Re: Certification Submittal for Final Building Certificate of Occupancy for
Kinesio Taping Bldg Addn, [G-18 / D1]
3901 Georgia St. NE
Architect's Stamp Dated 09/25/07

**Re: Kinesio Taping Building Addition, 3901 Georgia Street NE,
Approval of Permanent Certificate of Occupancy (C.O.)
Engineer's Stamp dated 03/14/07 (G-18/D001)
Certification dated 10/01/07**

Re: Traffic Circulation Layout (TCL) Submittal for Building Permit Approval for
Offices and Warehouse for Kinesio Taping Building [G-18/D-001]
(3901 Georgia), Albuquerque, NM
Engineer's/Architect's Stamp Dated 04/12/2007

**Re: 3901 Georgia NE Building F, Traffic Circulation Layout, Architect's
Stamp dated 3-20-07 (G18-D001)**

TRAFFIC CIRCULATION LAYOUT SITE PLAN

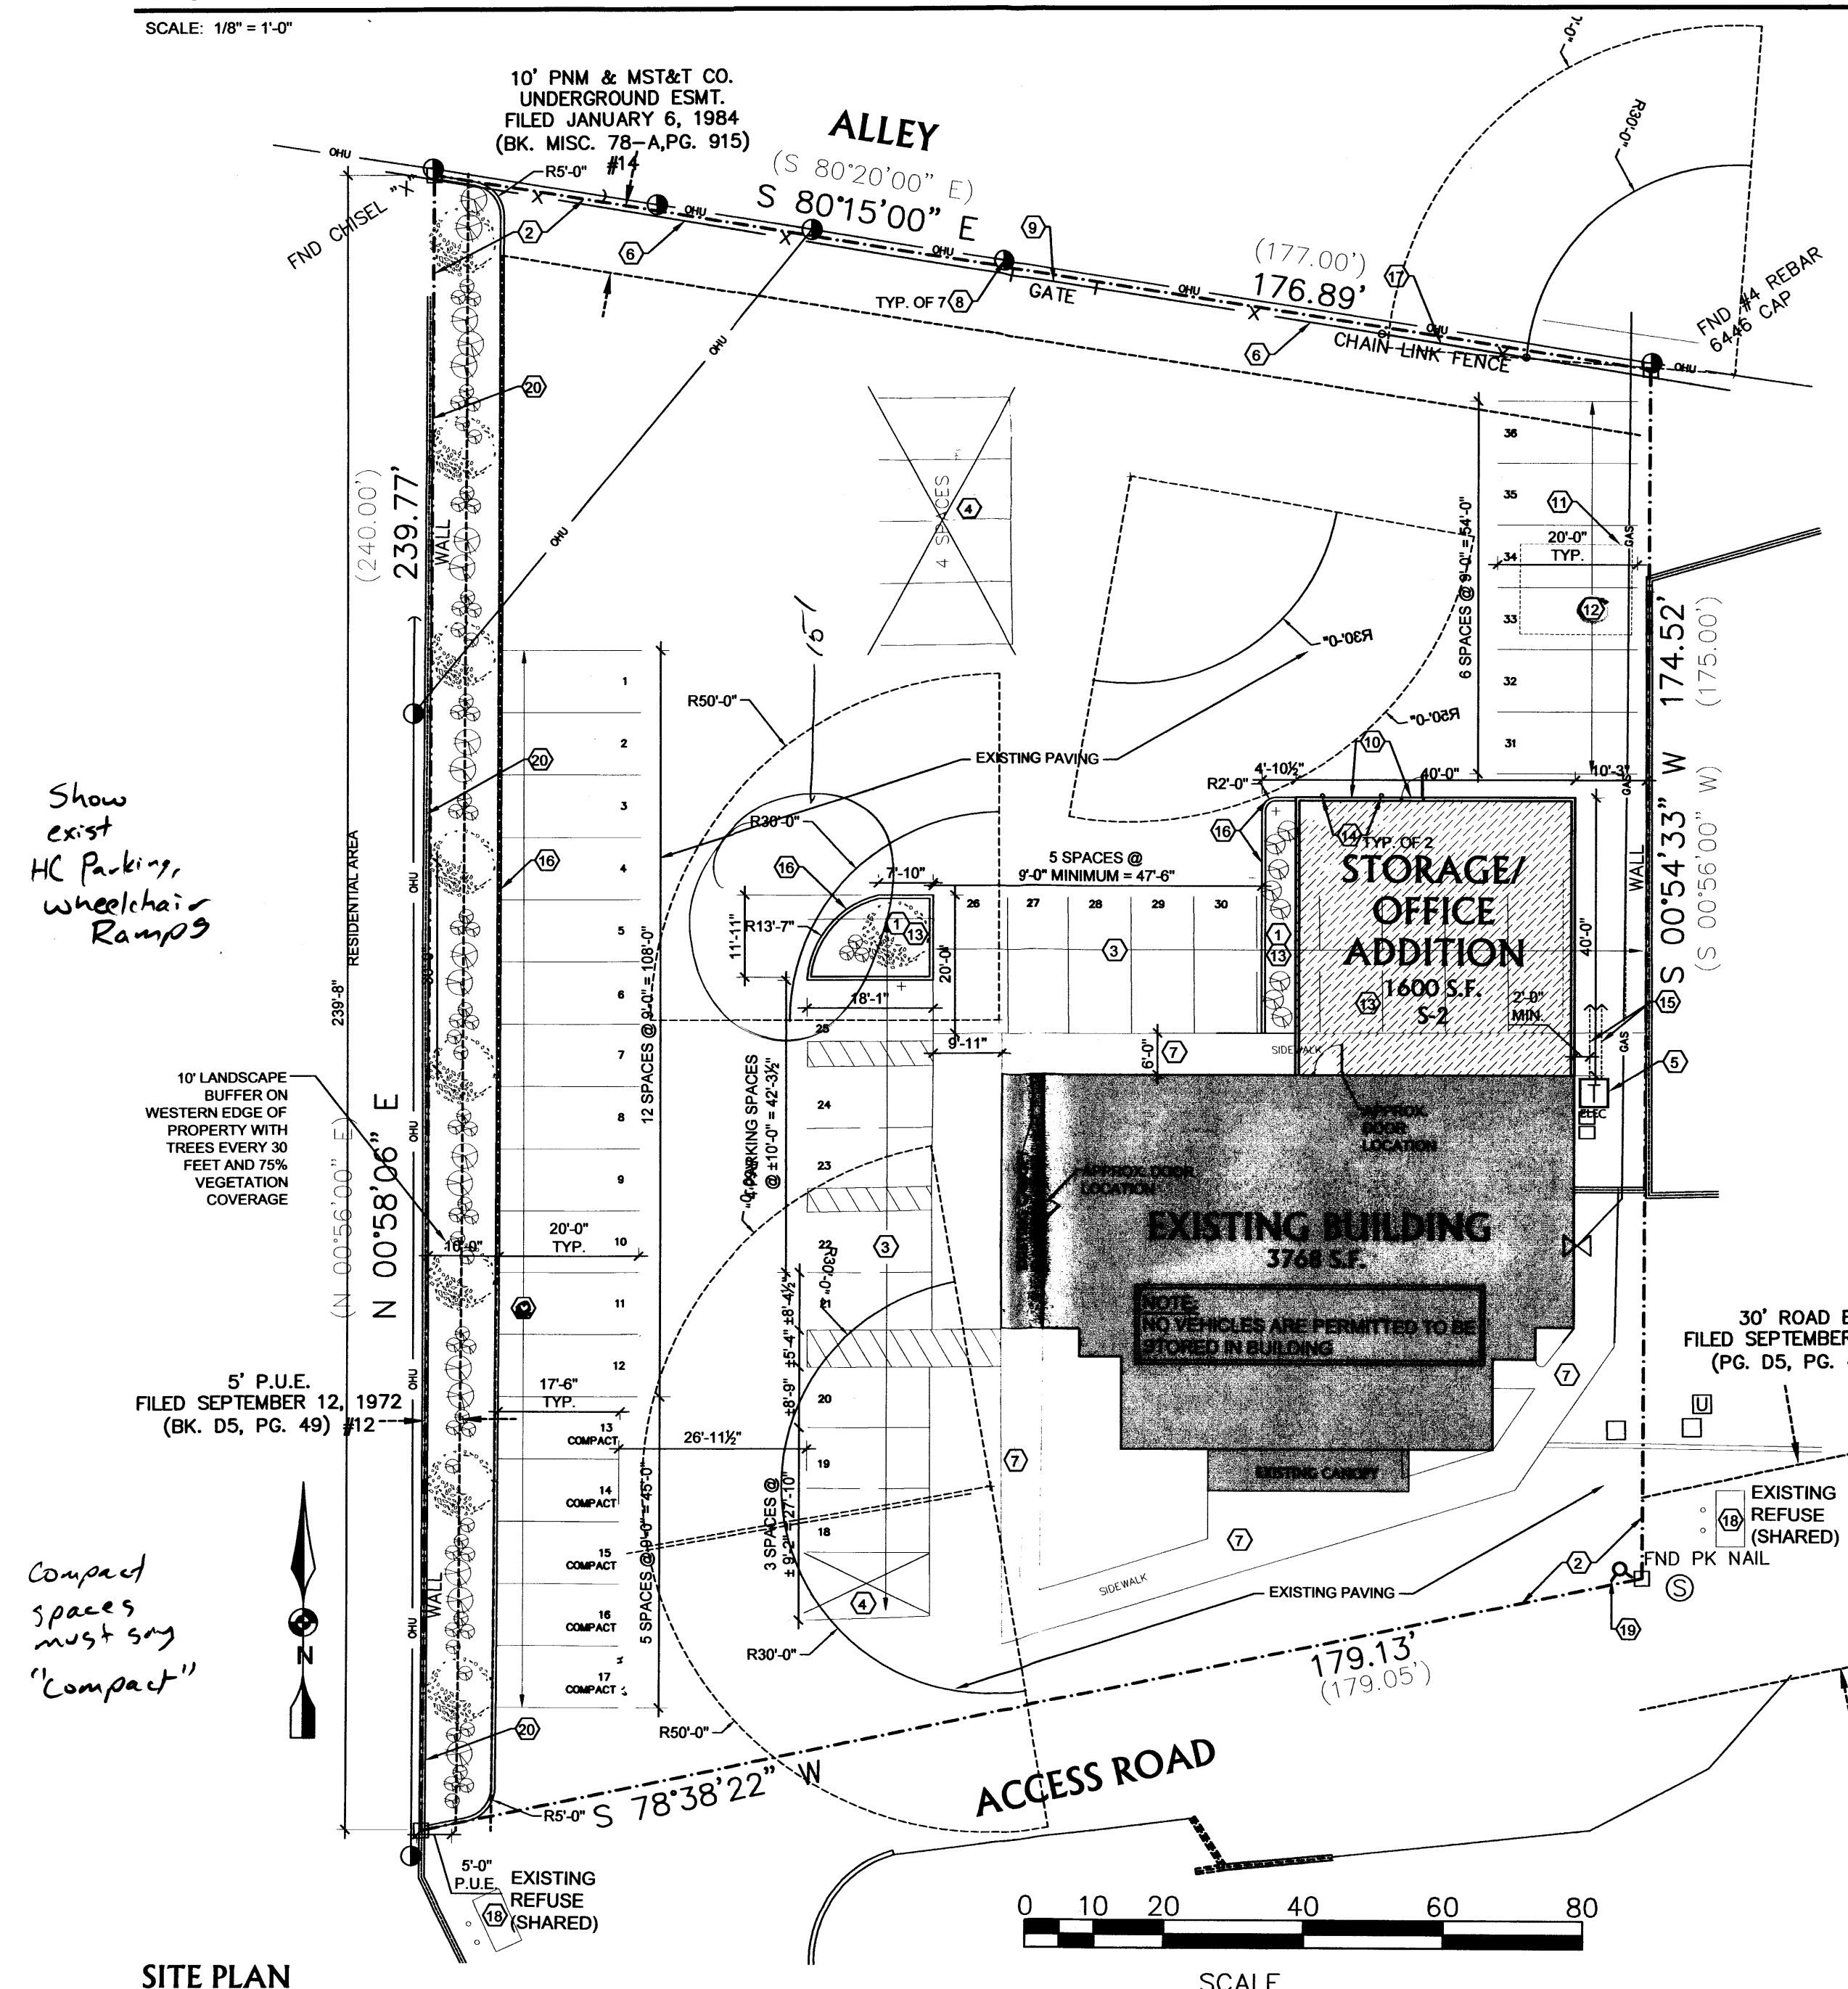
- ✓1. Provide a minimum 15' radius on the island on the north side of the proposed building.
- ✓2. All compact parking spaces will need to be stamped with the word, "COMPACT," on the pavement.
3. Show all existing verses proposed handicapped parking and wheelchair ramps.
